**Subject:** RE: Saltbox Unit 9 site Planning Condition 12 response Surface water

**Paul Cann**  
Principal Drainage Engineer  
Engineering Services

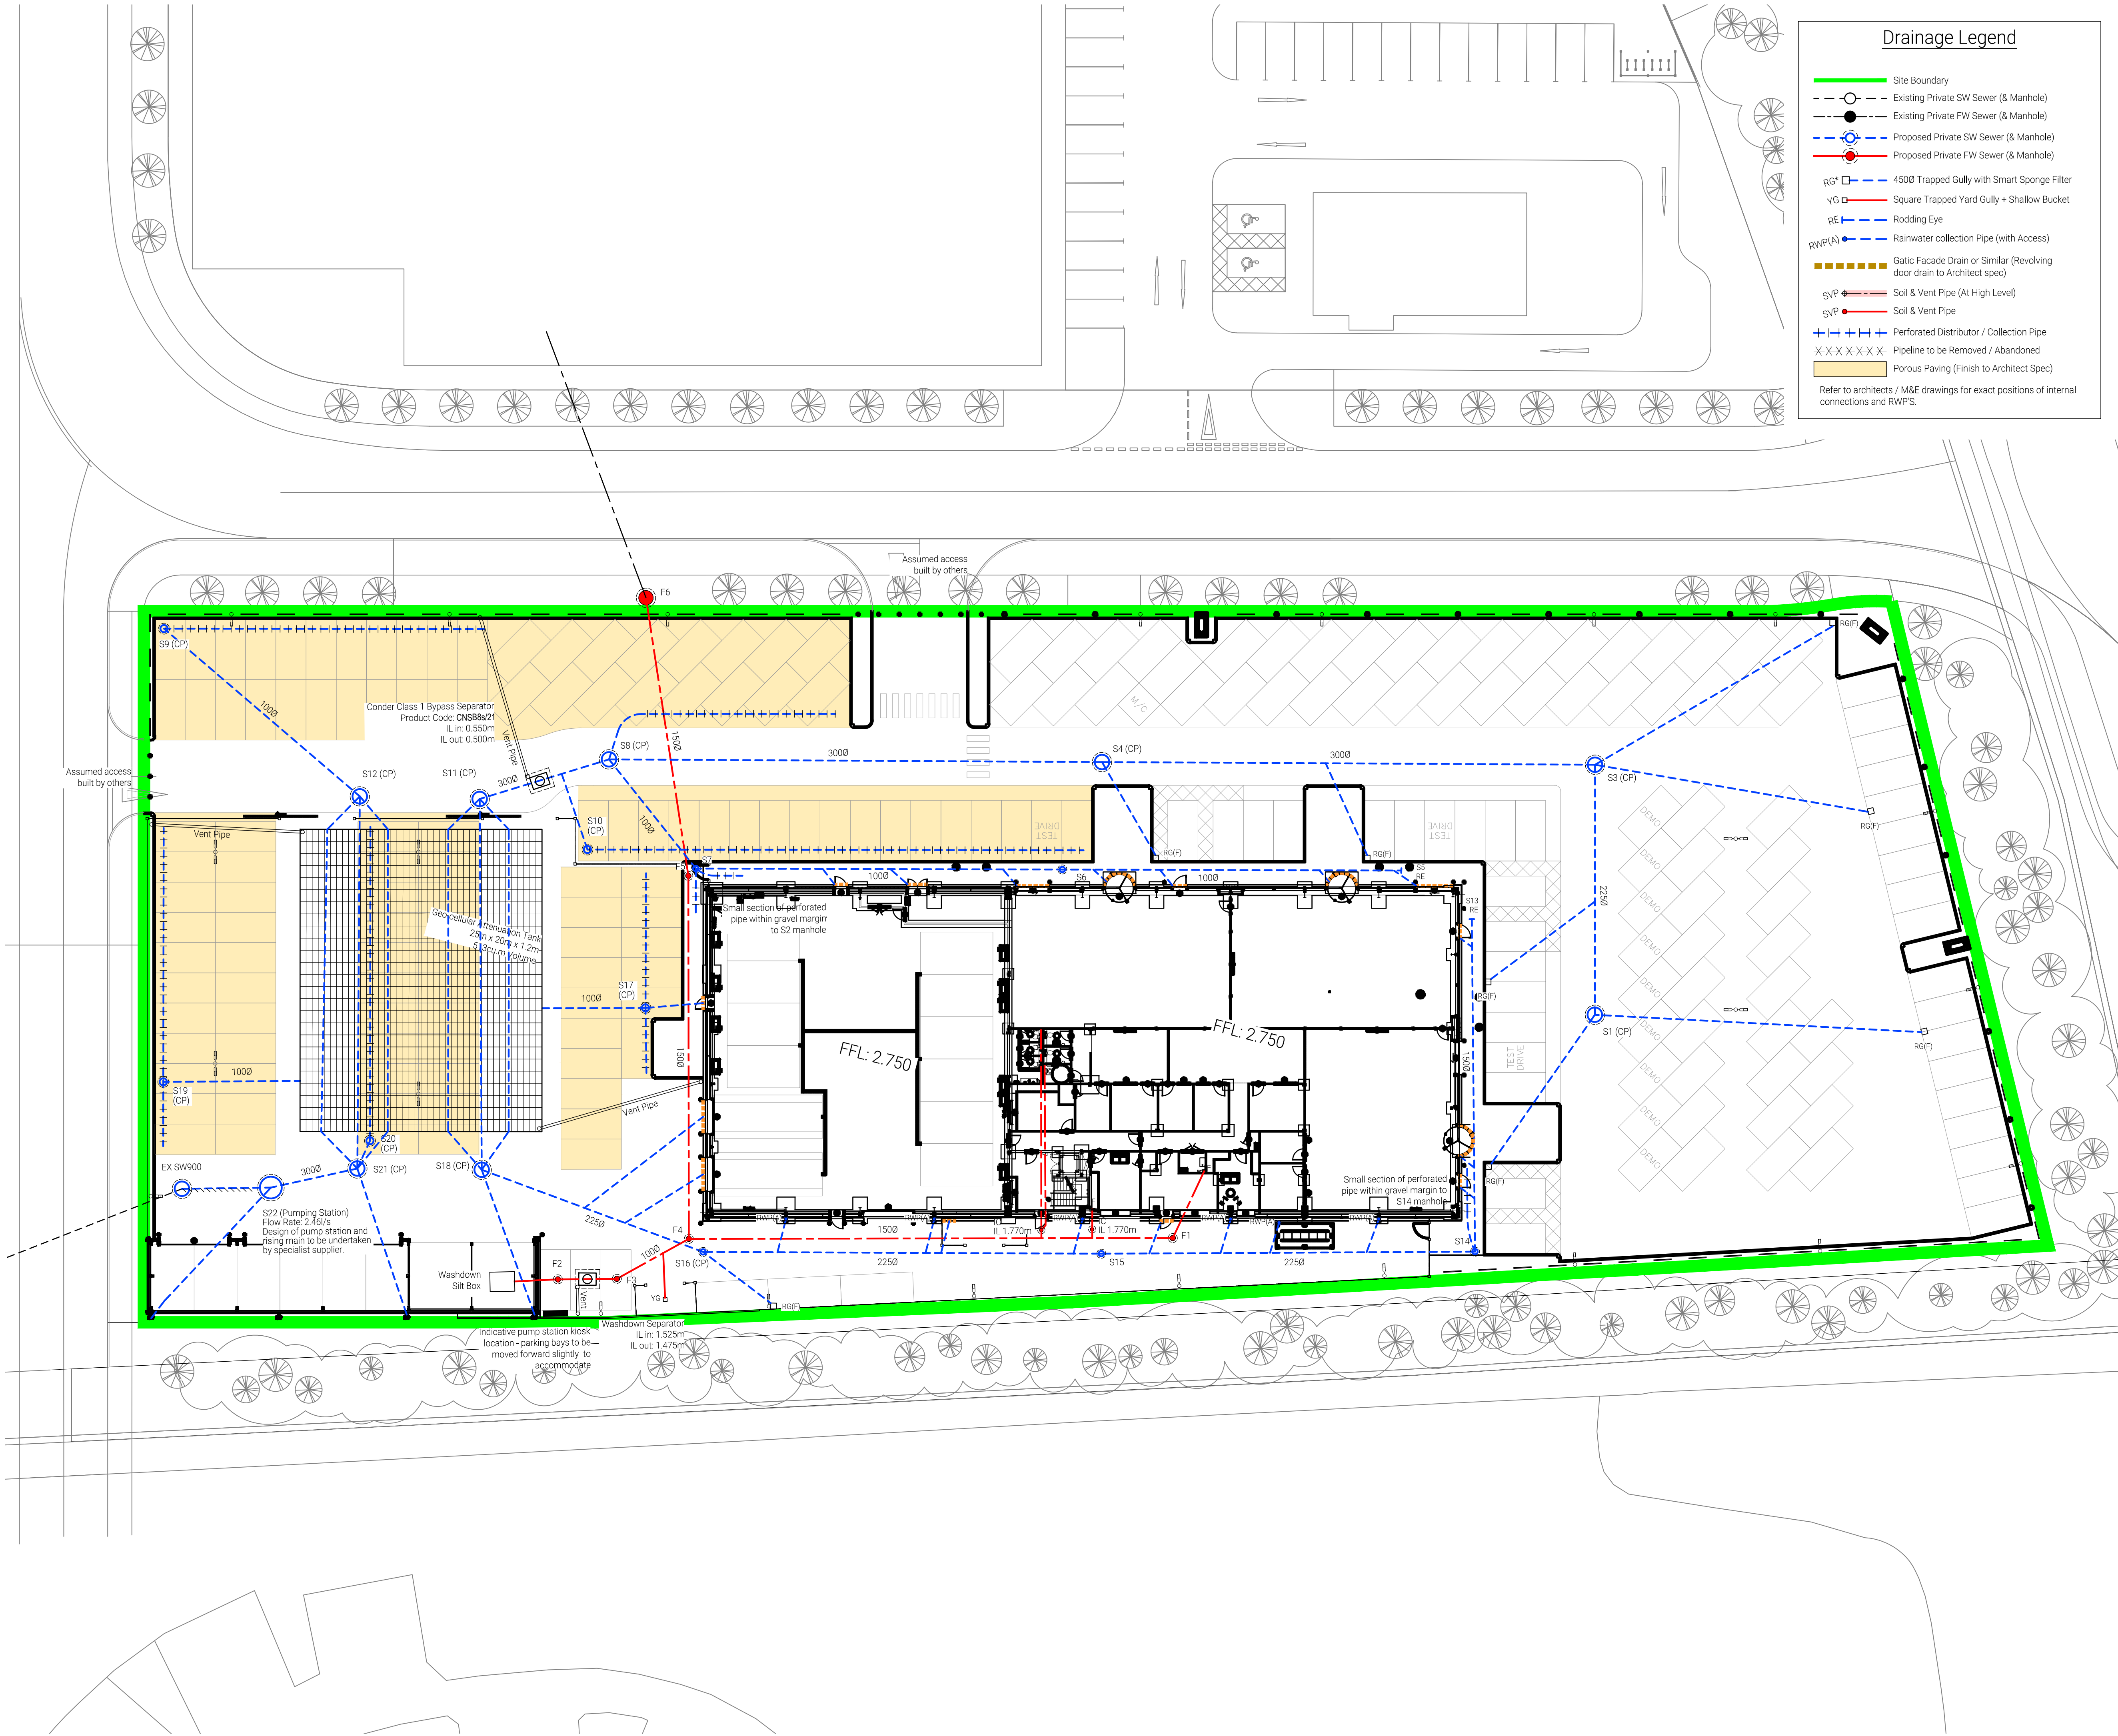
There is one thing I would like to verify at this stage; Have you checked the invert level of the 450mm pipe at existing manhole SW900? I note you have it as 1.280, I think the proposed level was 1.250?, but from 'as constructed' drawings I have seen it may be 1.657! (See enclosed).

I would suggest that these levels are double checked as are critical to any scheme. If it is necessary to relay offsite pipes to shallower gradients to help achieve the desired solution, then clearly that is a discussion to be had between the relevant parties.
